THE VICTORIAN SOCIETY

Our ref: 2012C/08/013
Your ref: CONVS/3/2012/0709

St John, Hurst Green, Lancs. (Grade II, 1838) – Creation of composting lavatory in churchyard, with creation of access doorway requiring alteration of aisle window

North Elevation.

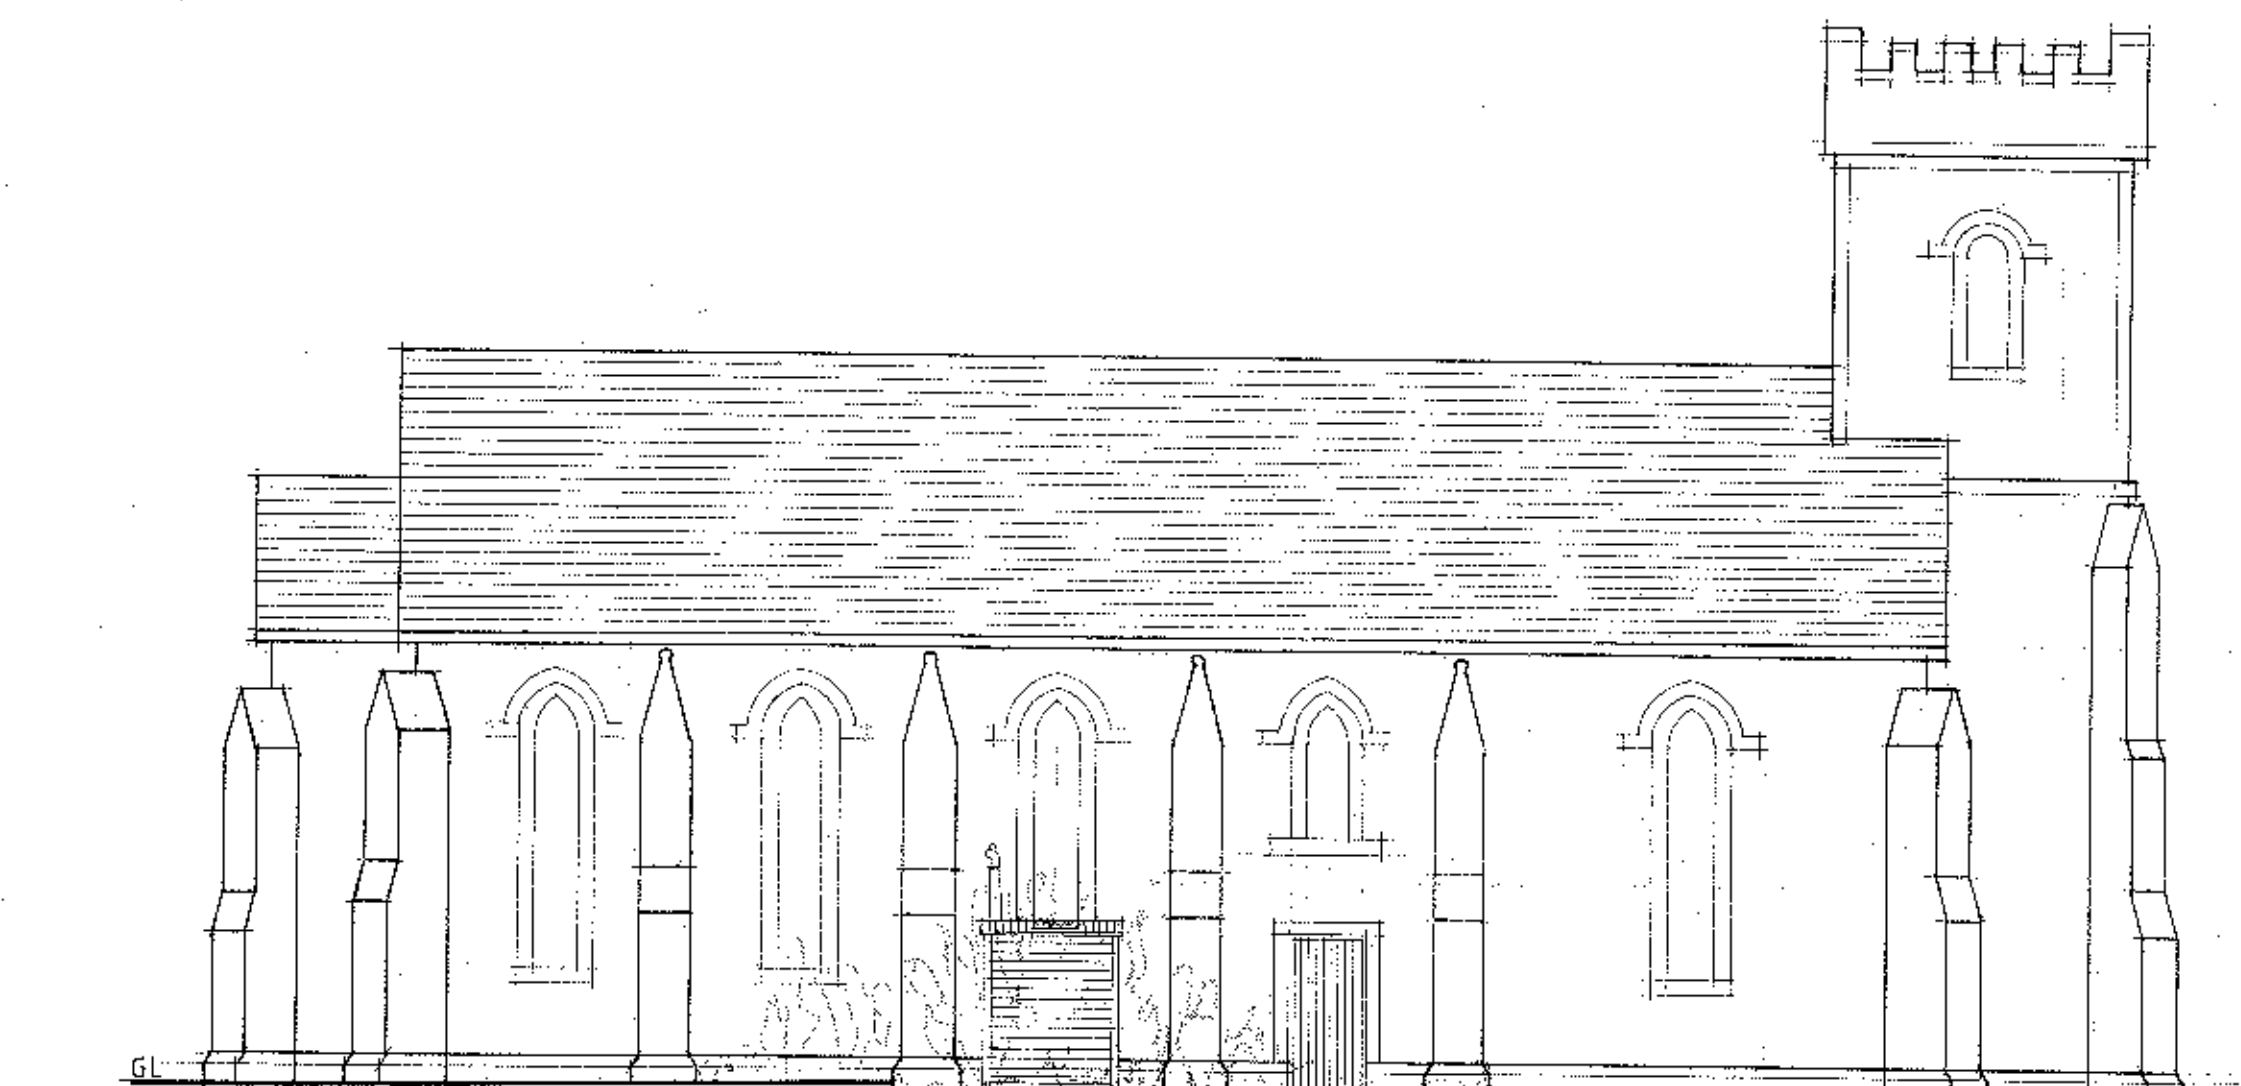
The Society has no principled objection to the works. However, we question why it is not intended to site the lavatory in the churchyard directly opposite the access doorway created for it into the aisle of the church. The north elevation shows that, as proposed, the plans would result in the window adjacent to the doorway being obscured by the lavatory, which seems unfortunate and unnecessary. We would suggest that this detail is emended before permission is granted.
